From: Chris Lauritzen <chris.lauritzen@machenergyaustralia.com.au>
Sent: Thursday, 7 June 2018 4:19 PM
To: Matthew Sprott
Cc: Howard Reed; Tertius Greyling; Stirling Bartlam
Subject: RE: Request for Info - Landowner rights
Attachments: Mount Pleasant Operation - Proposed Changes to Draft Consolidated Consen....docx; MPO DC Appendix 5 Figures.zip

As you are aware the Department is currently finalising its assessment of the proposed Modification 3 to the Mt Pleasant coal mine (DA 92/97). In finalising the Department's recommendations concerning acquisition and mitigation rights, the Department has identified two key matters that it wishes to draw to your attention.

As currently depicted, the Figures in Appendix 5 of the Department's draft conditions of consent identify landholdings by reference to a specific receiver number assigned to a common landowner. While the Department understands the reasons for showing common land ownership, this has resulted in a few cases where a single reference number has been shown against different properties around the mine that have different classes of acquisition and mitigation rights.

The Department is therefore seeking a revised version of the

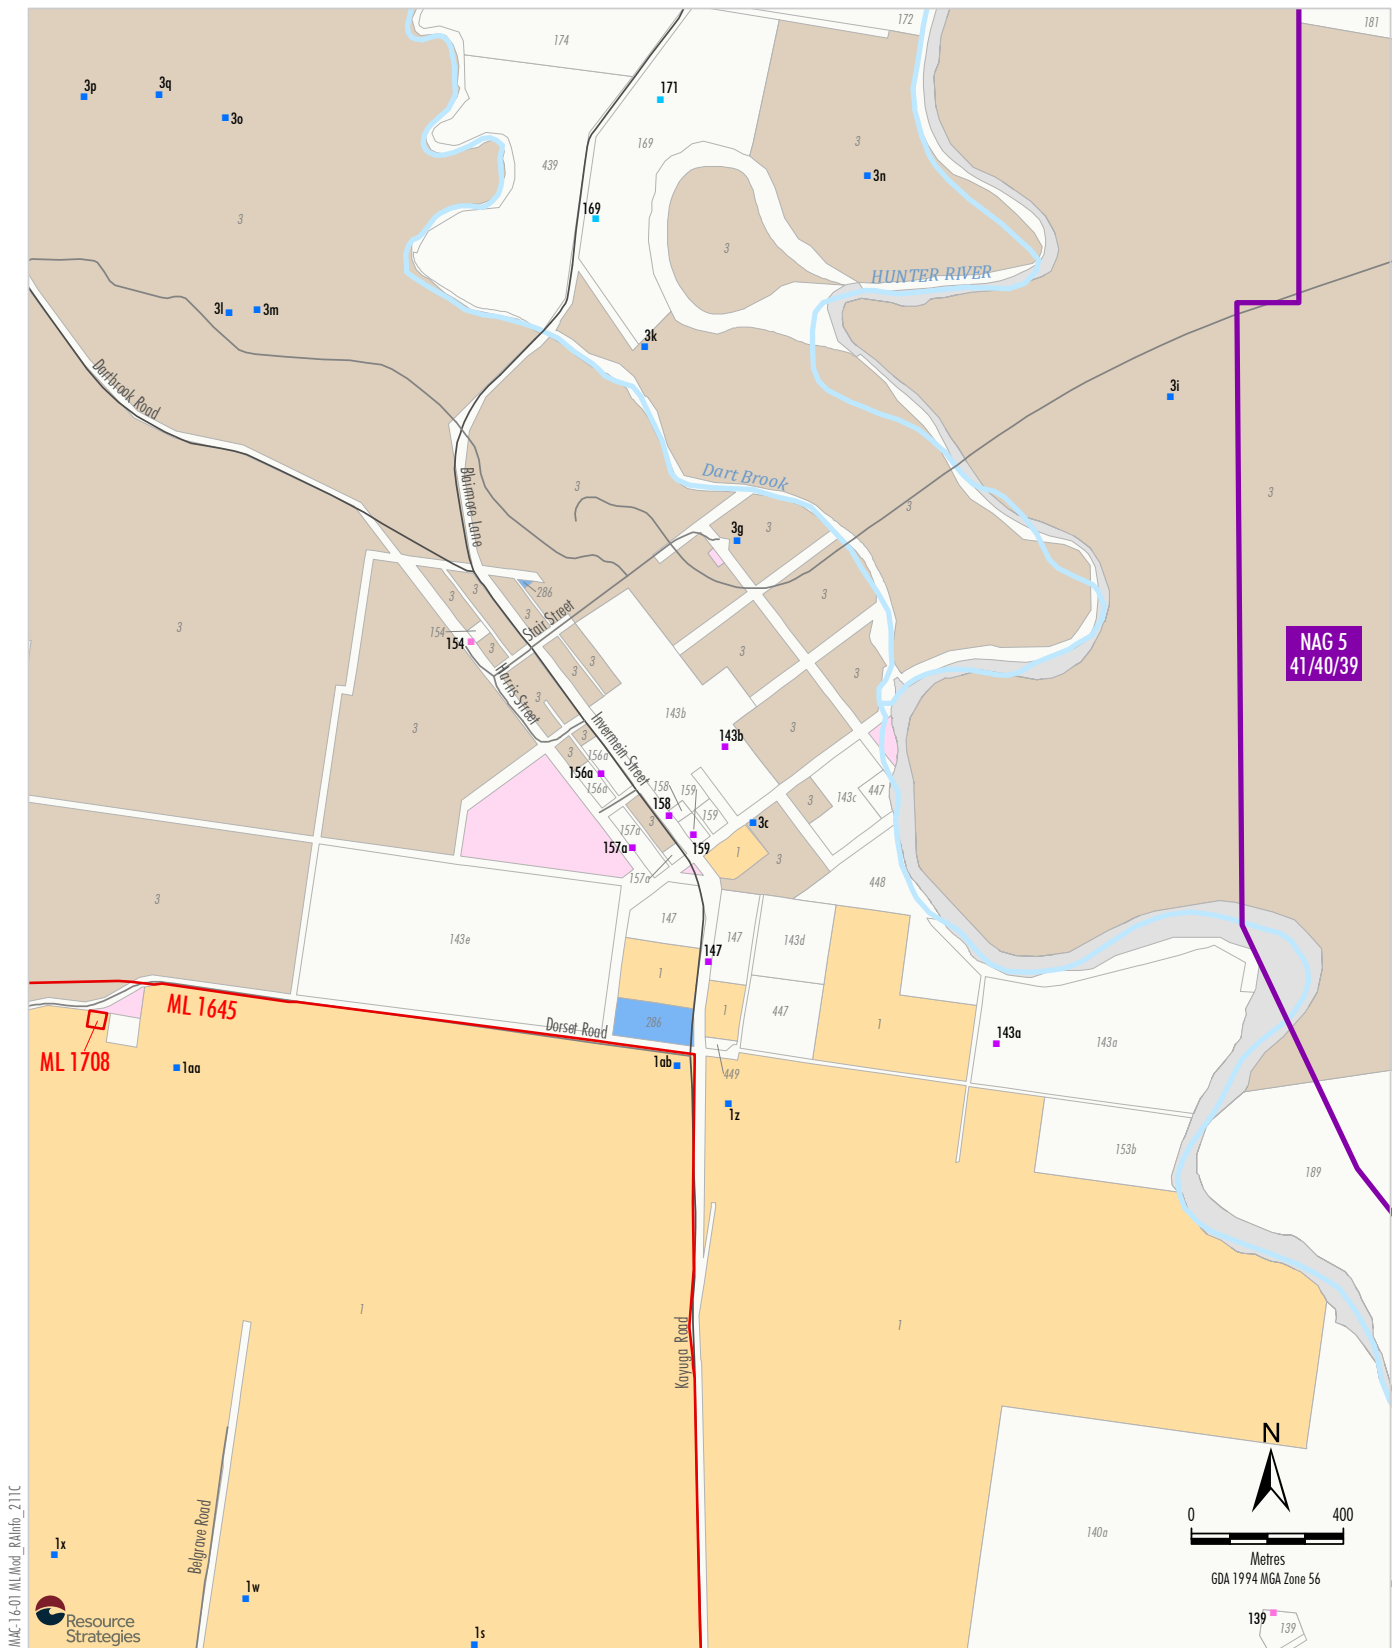
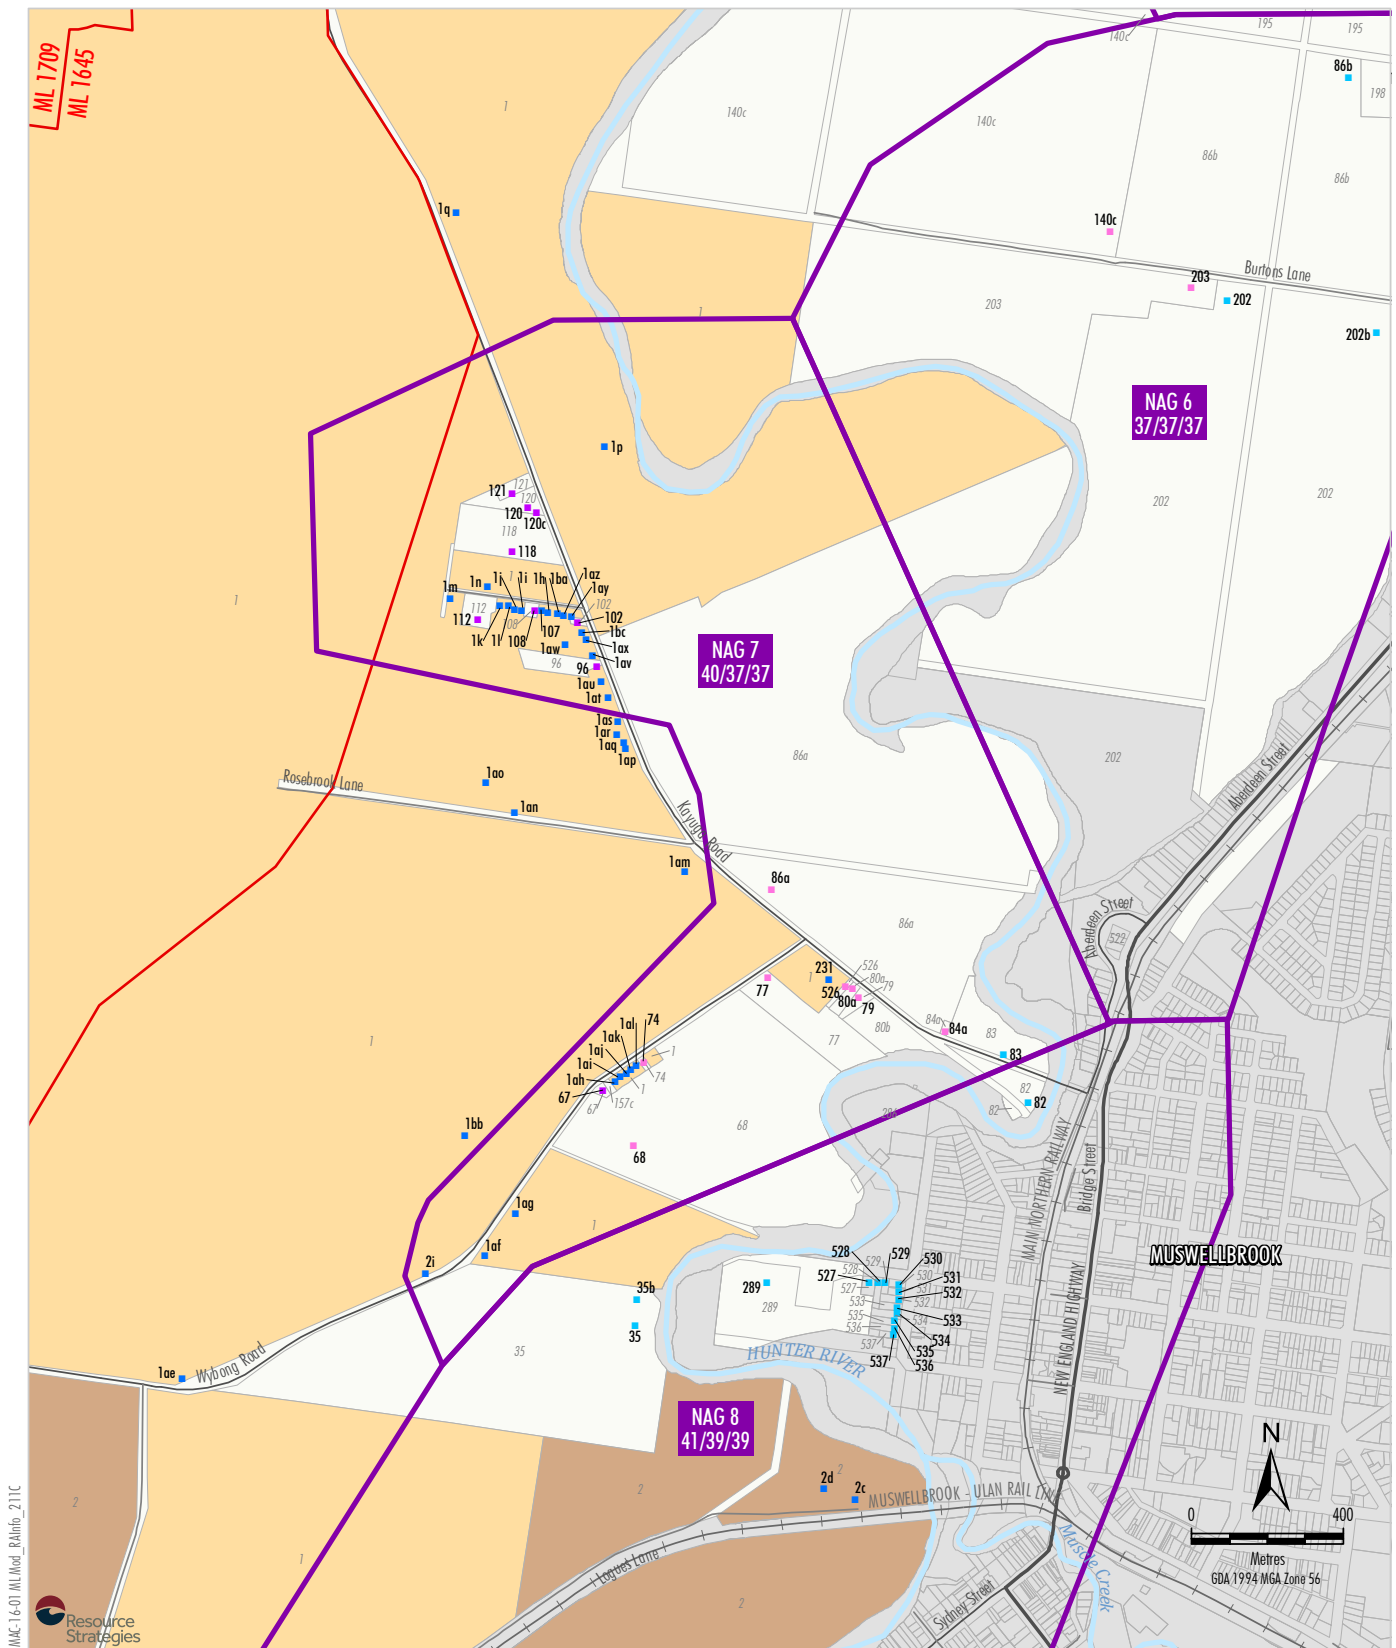
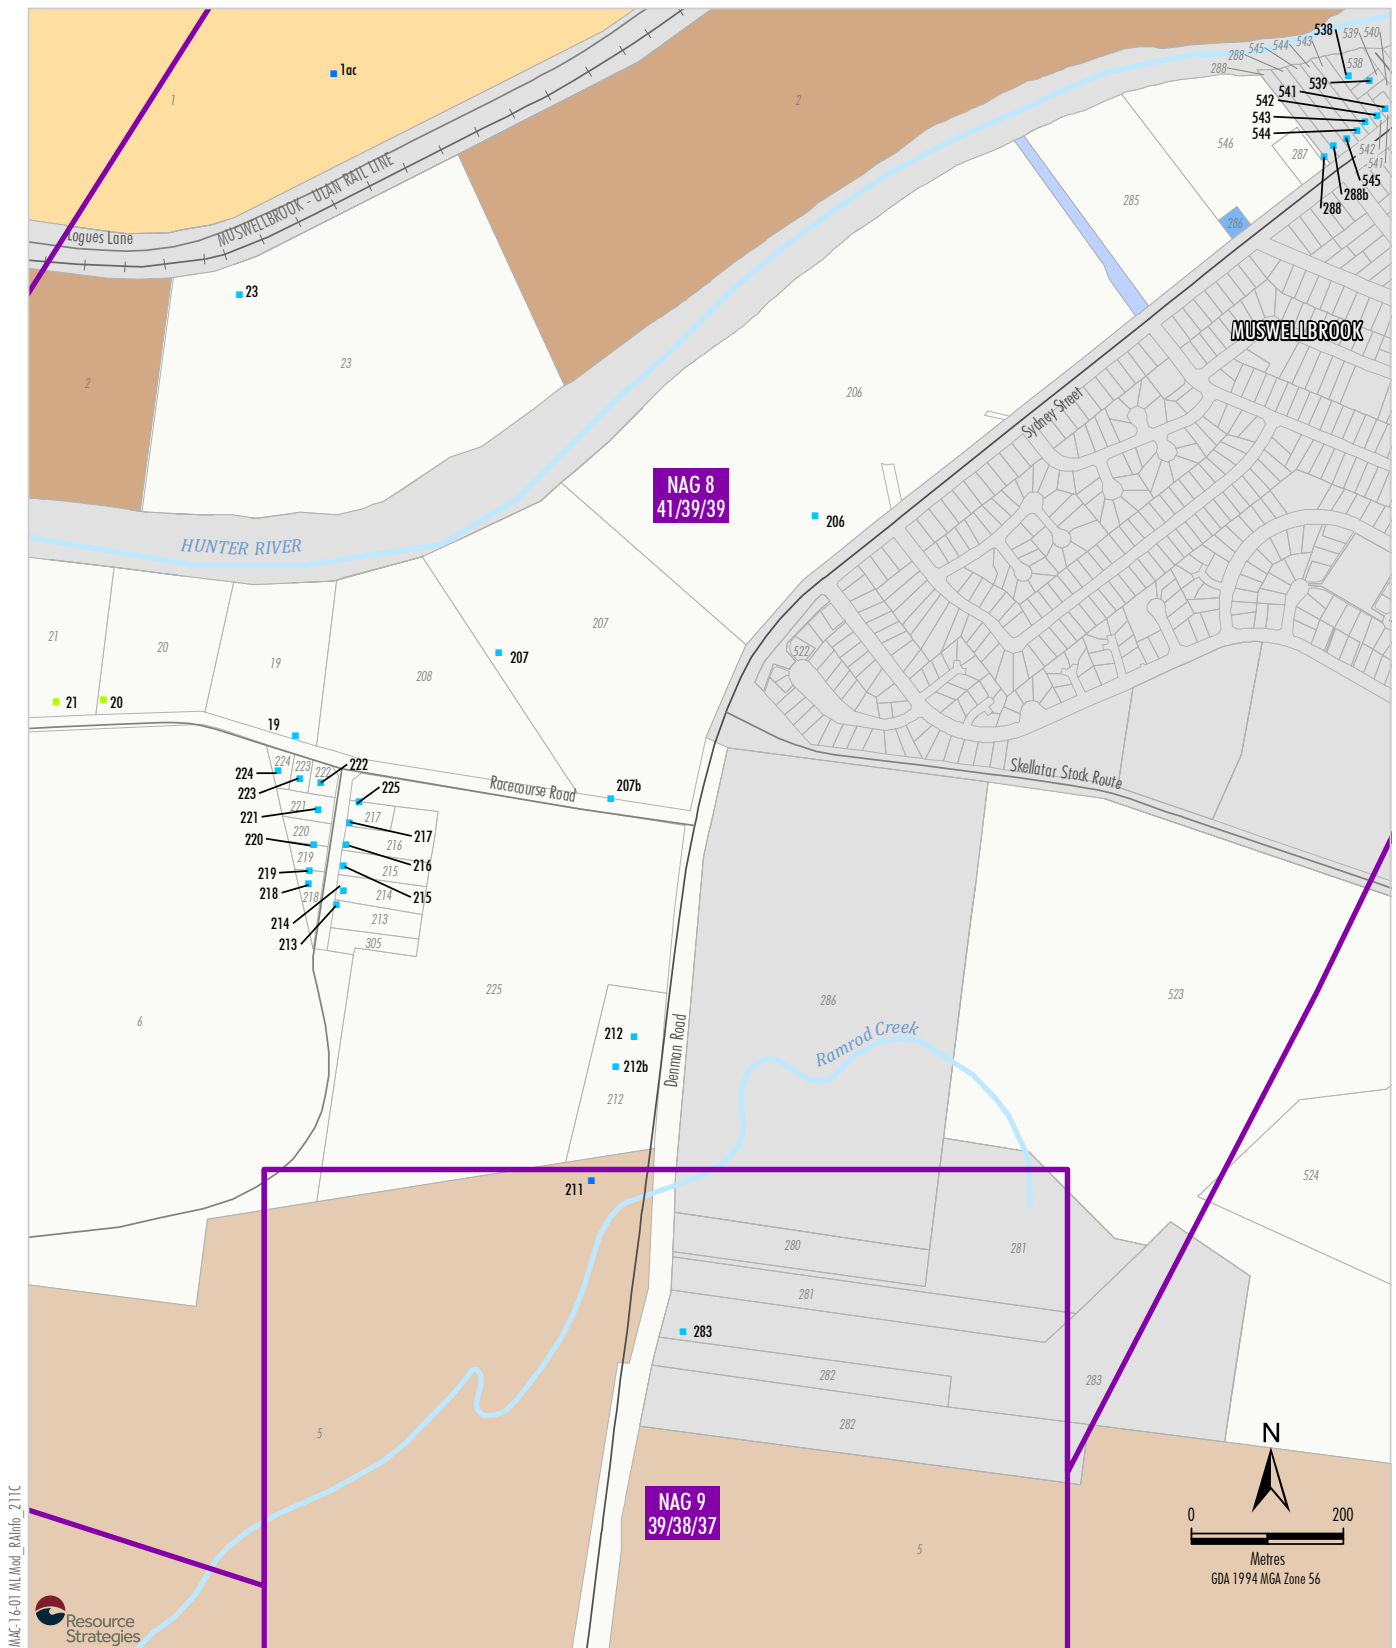
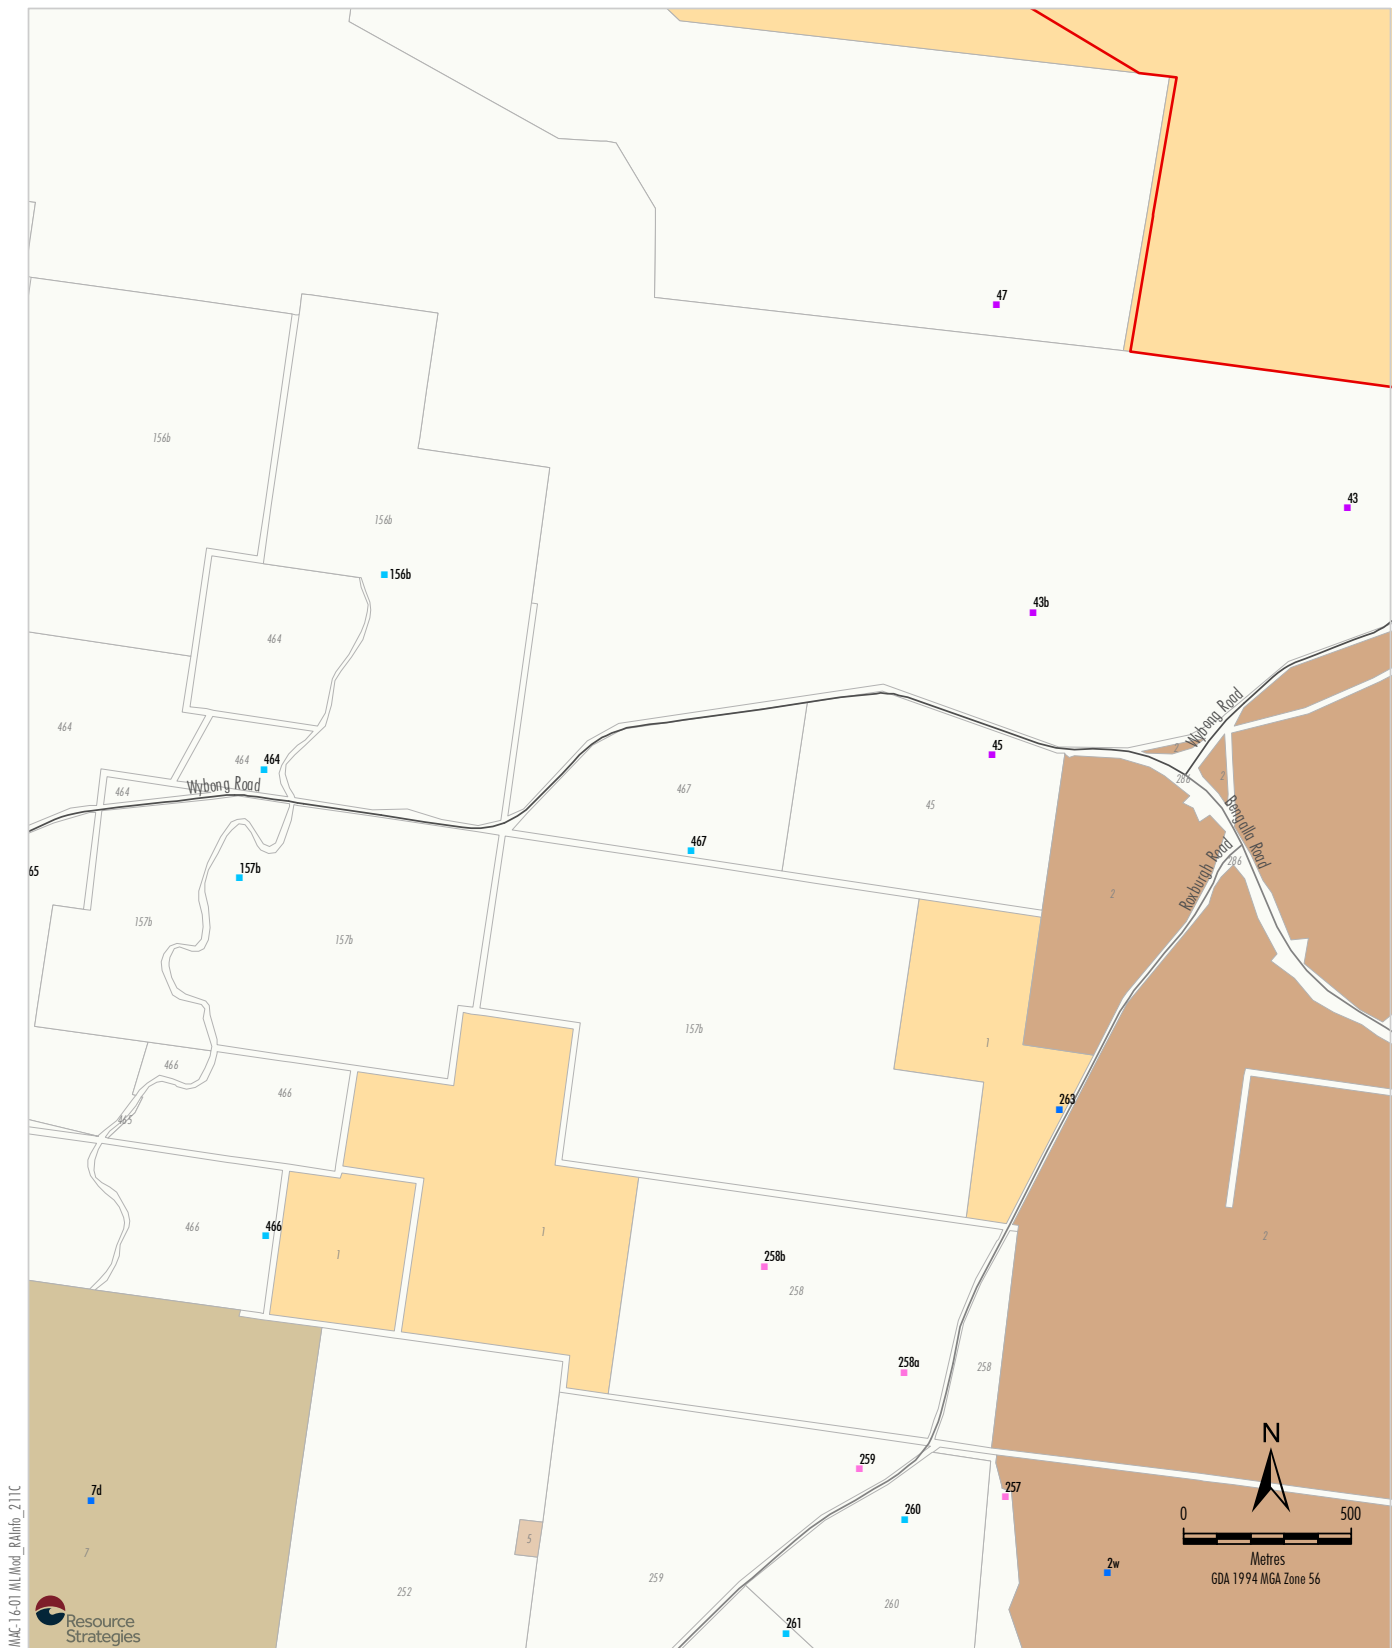
Since the Department's most recent consultation with MACH Energy on the draft conditions of consent, we have identified two receivers that should have been included in the Noise Mitigation Table in Condition 2 of Schedule 3. These receivers are Receiver 67 (already subject to acquisition for air quality) and Receiver 84.

The Department has also identified some concerns with the numbering of Receiver locations surrounding the project, which have the potential to deleteriously affect MACH Energy's interests in relation to acquisition and mitigation obligations.

We don't necessarily agree that residence 67 should be added to Table 2 (mitigation upon request), as none of the other residences listed in Table 1 are also listed in Table 2 (i.e. Condition 2 applies the mitigation obligation to both Tables 1 and 2).

- We concur that 84 (now 84a) should be added to Table 2 as in the consent previously it was erroneously listed in NAG 8, whereas it is in NAG 7.
- We have amended the property numbering to assign letters to contiguous landholdings, where a party owns landholdings both in, and outside of, either the acquisition or mitigation zones.
- Adopting this approach necessitated renumbering some residences, and hence also results in some corresponding minor changes to the drafts of Tables 1 and 2 (tracked in the attached word document).
- We also updated the colour coding of residences on the plans to reflect the latest lists of those with acquisition rights or mitigation rights, including the two residences that are to be addressed by Bengalla Mine in the first instance (new green colour).

Attached are the updated 5-1 to 5-7 in PDF and JPEG format for inclusion in the draft Consent.
